January 4, 2021

Re: **Response to TCL Comments Dated 12-30-2020 (K16d022A)**
The Strider
Address: 109 Vassar Drive SE

This letter serves to address your review comments of the Traffic Circulation Layout (TCL) submitted for The Strider project. As a continually developing project, minor revisions have been made to the site plan to coordinate with updates to the building design. However, the primary intent of the site plan remains unchanged from the original submittal.

PROJECT	109 VASSAR DRIVE S.E. REDEVELOPMENT
	133 VASSAR DRIVE S.E.
	ALBUQUERQUE NM 87106
TITLE	TRAFFIC CIRCULATION LAYOUT

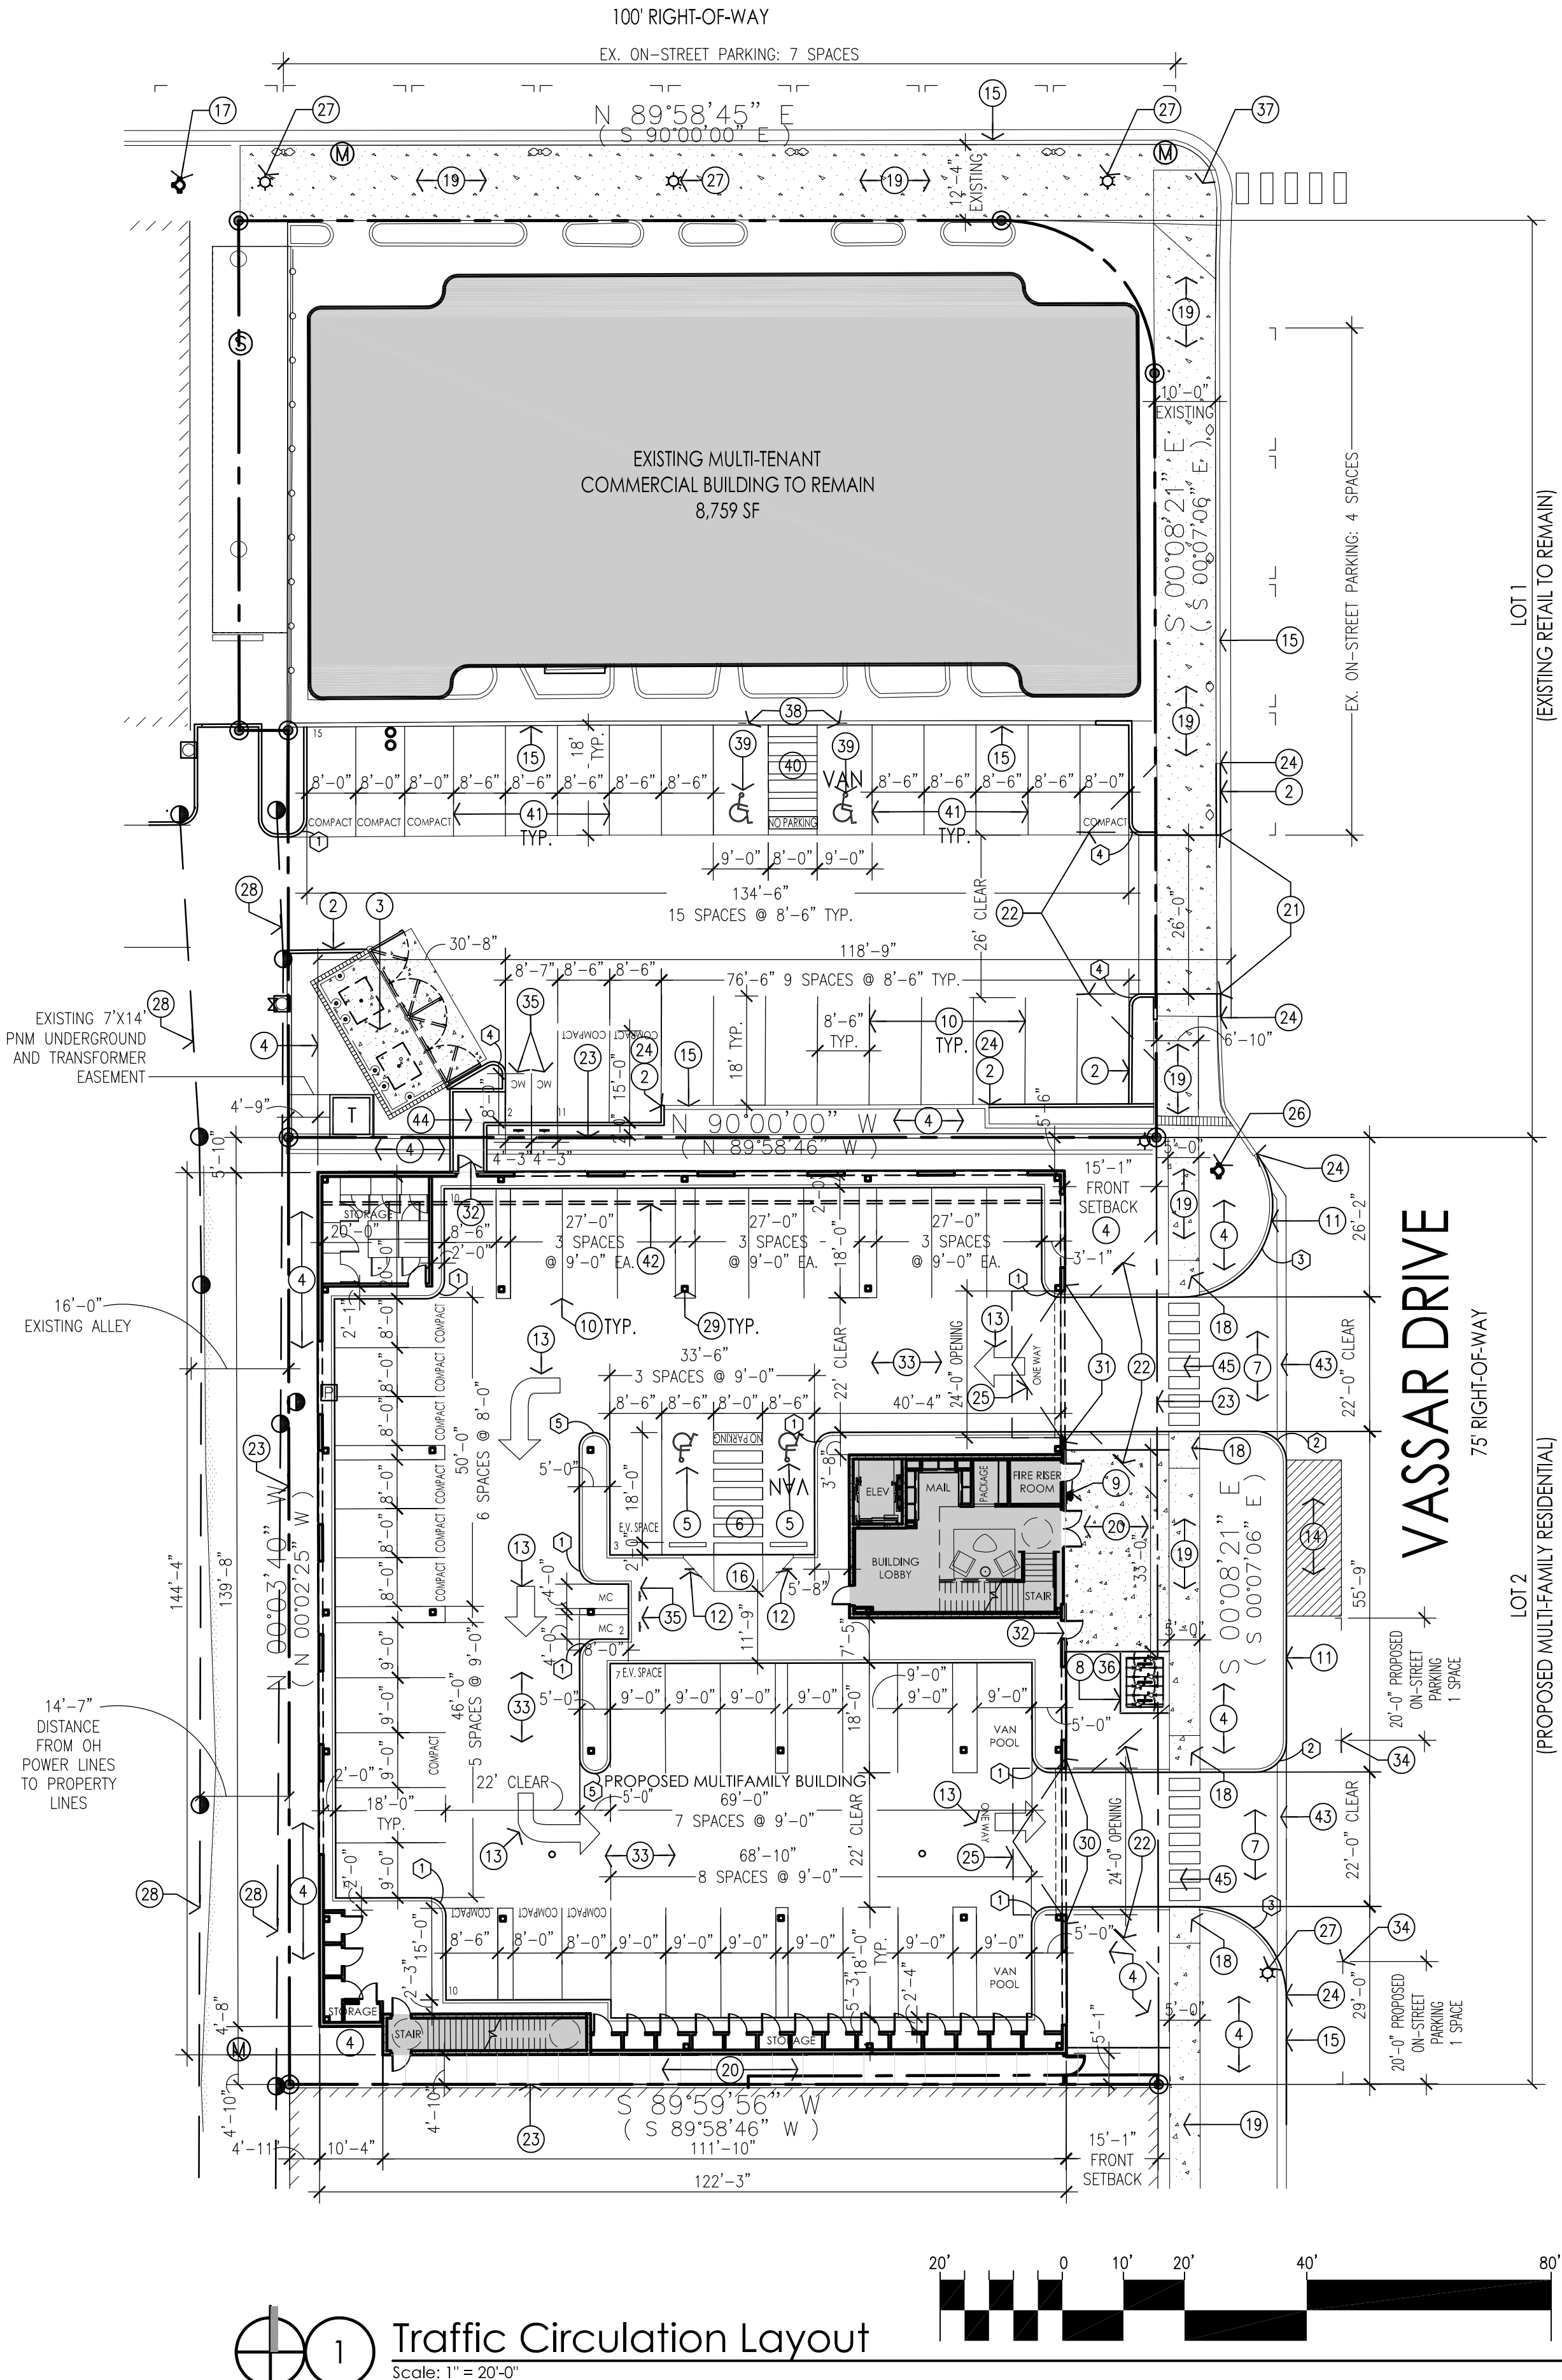
- 2) Sealed documents: The submitted TCL drawing sheets are now stamped and signed by a registered architect: John Douglas Heller, NM Stamp No. 2827.
- 3) Existing easements: Only one existing easement exists on the property: a 7'x14' PNM easement for underground and transformer components. This easement is now shown on the TCL site plan.

1 Typical Driveway Detail  
Scale: NTS (COA STD DETAIL 2426)

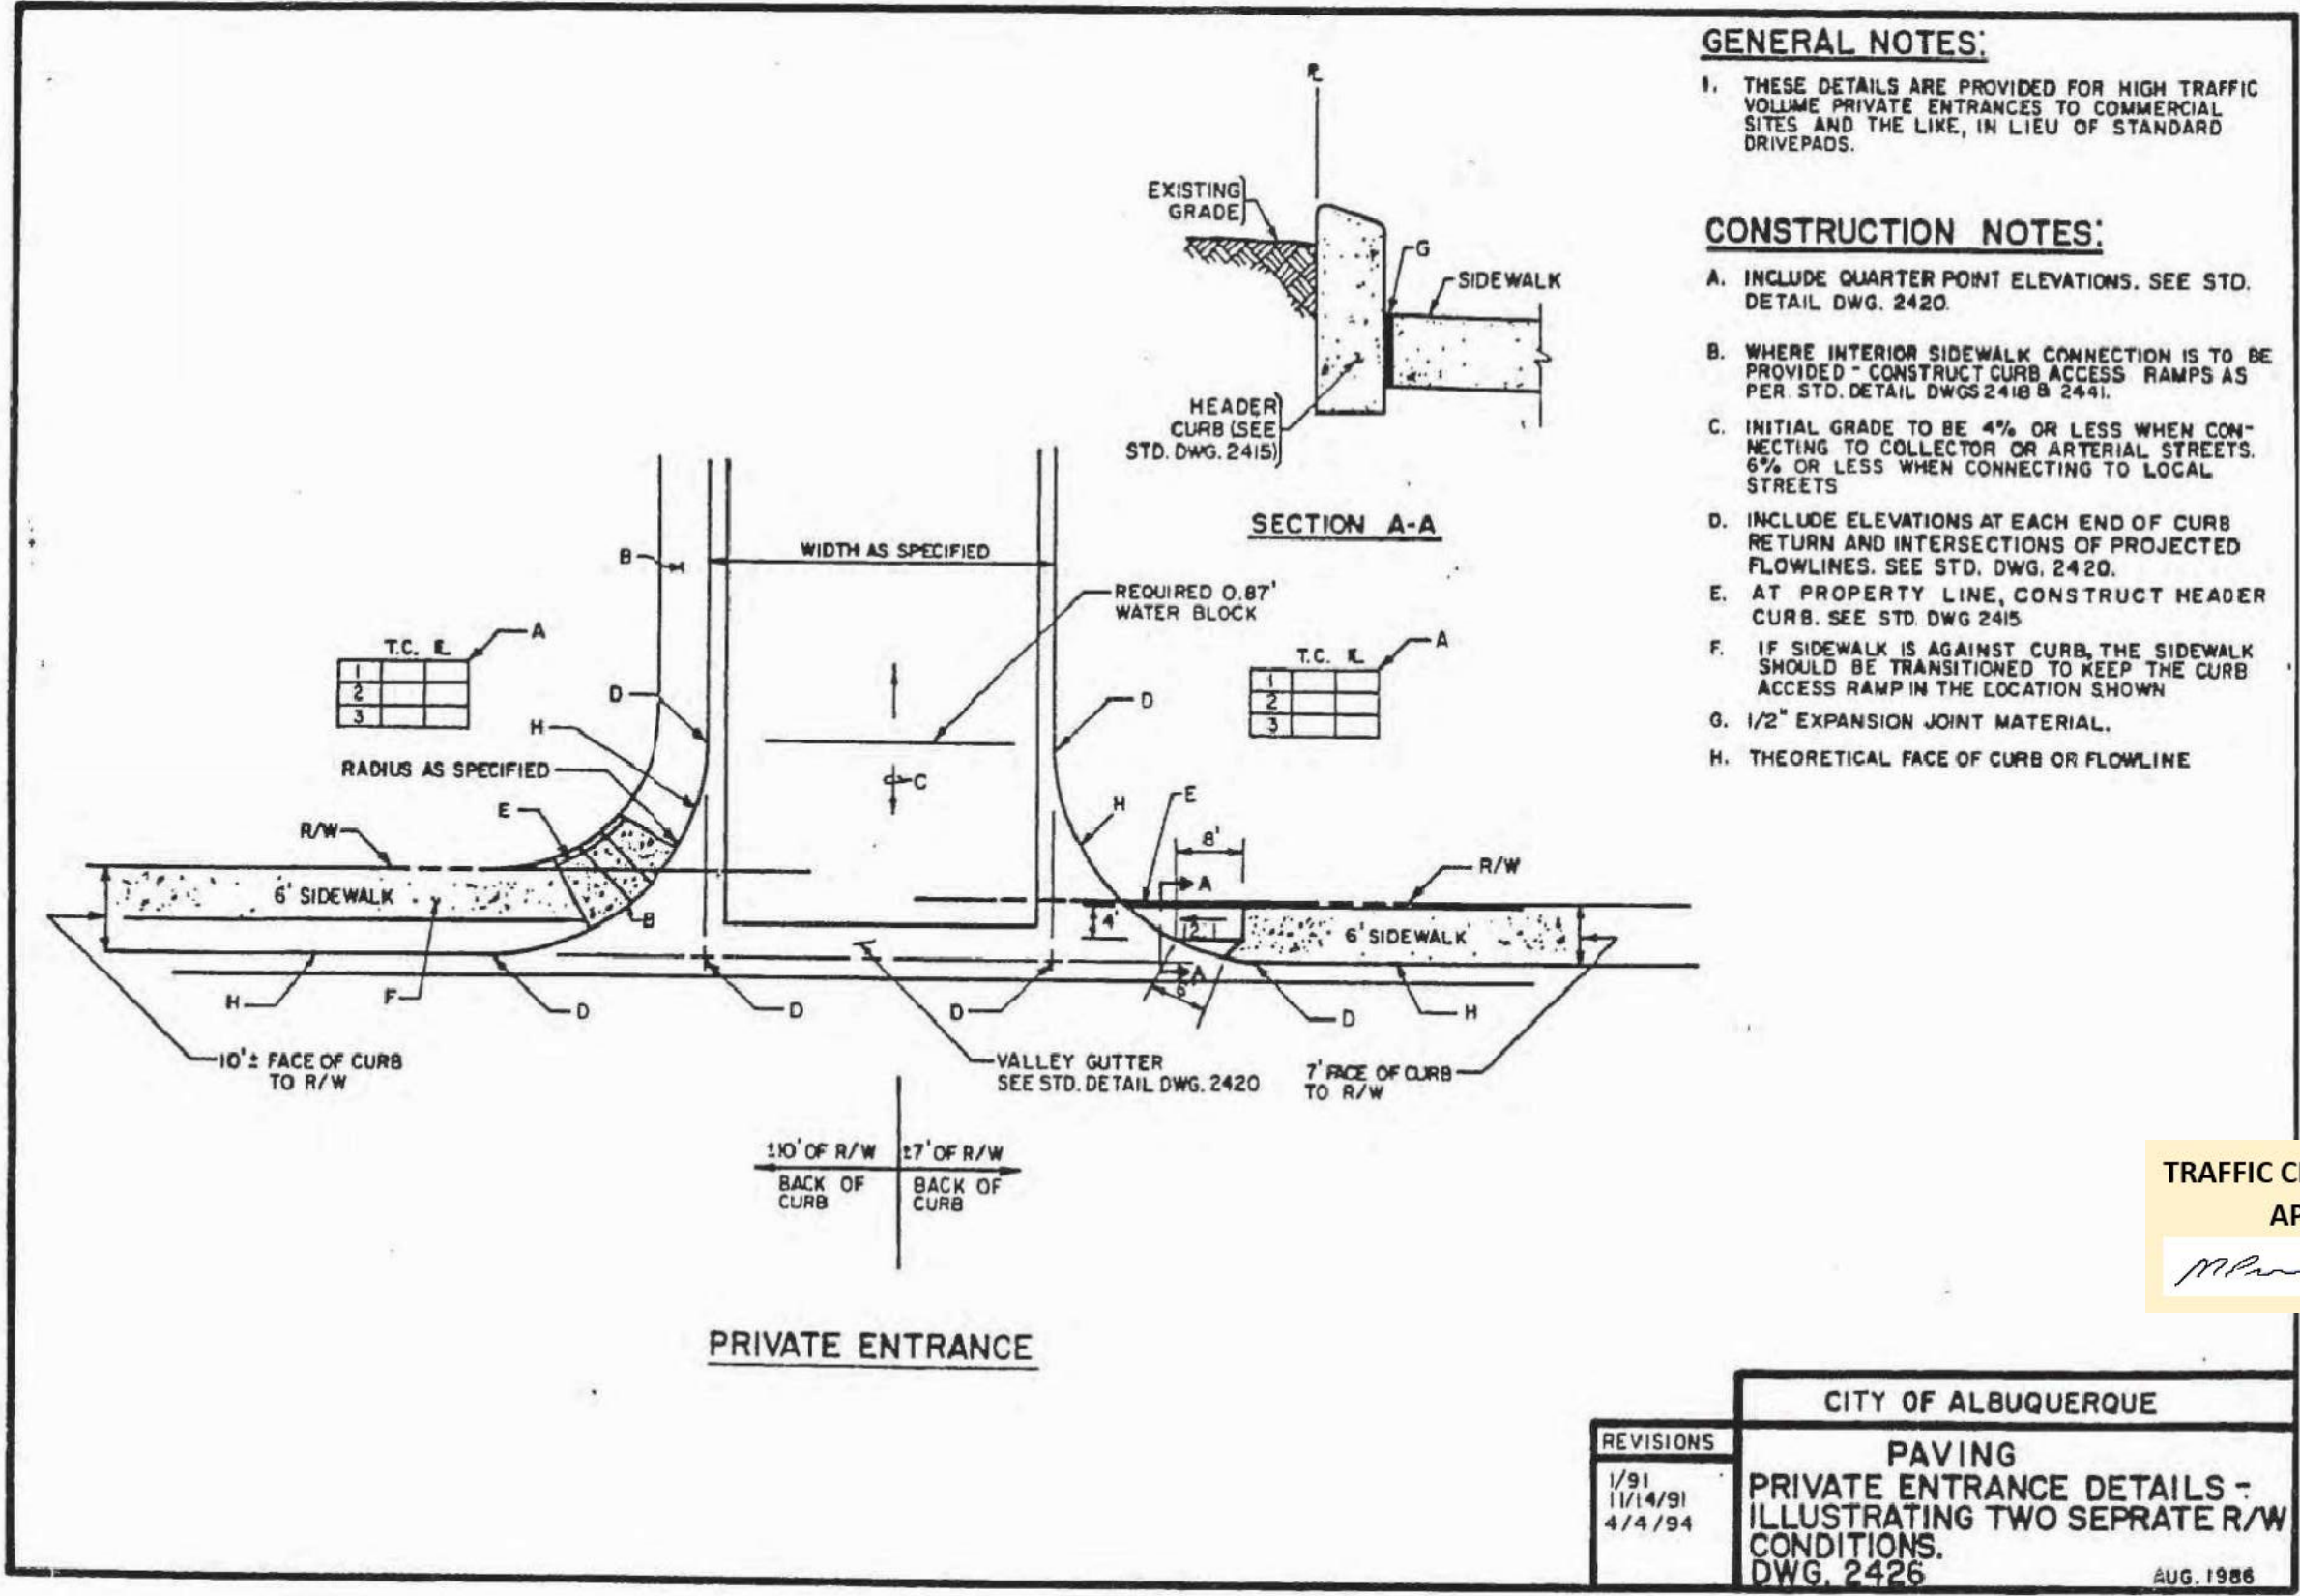
- 5) Access driveways: Both new access driveways are now noted on the TCL site plan, with the associated COA standard detail number. Additionally, a typical access driveway detail has been added to the typical site details sheet TCL003.
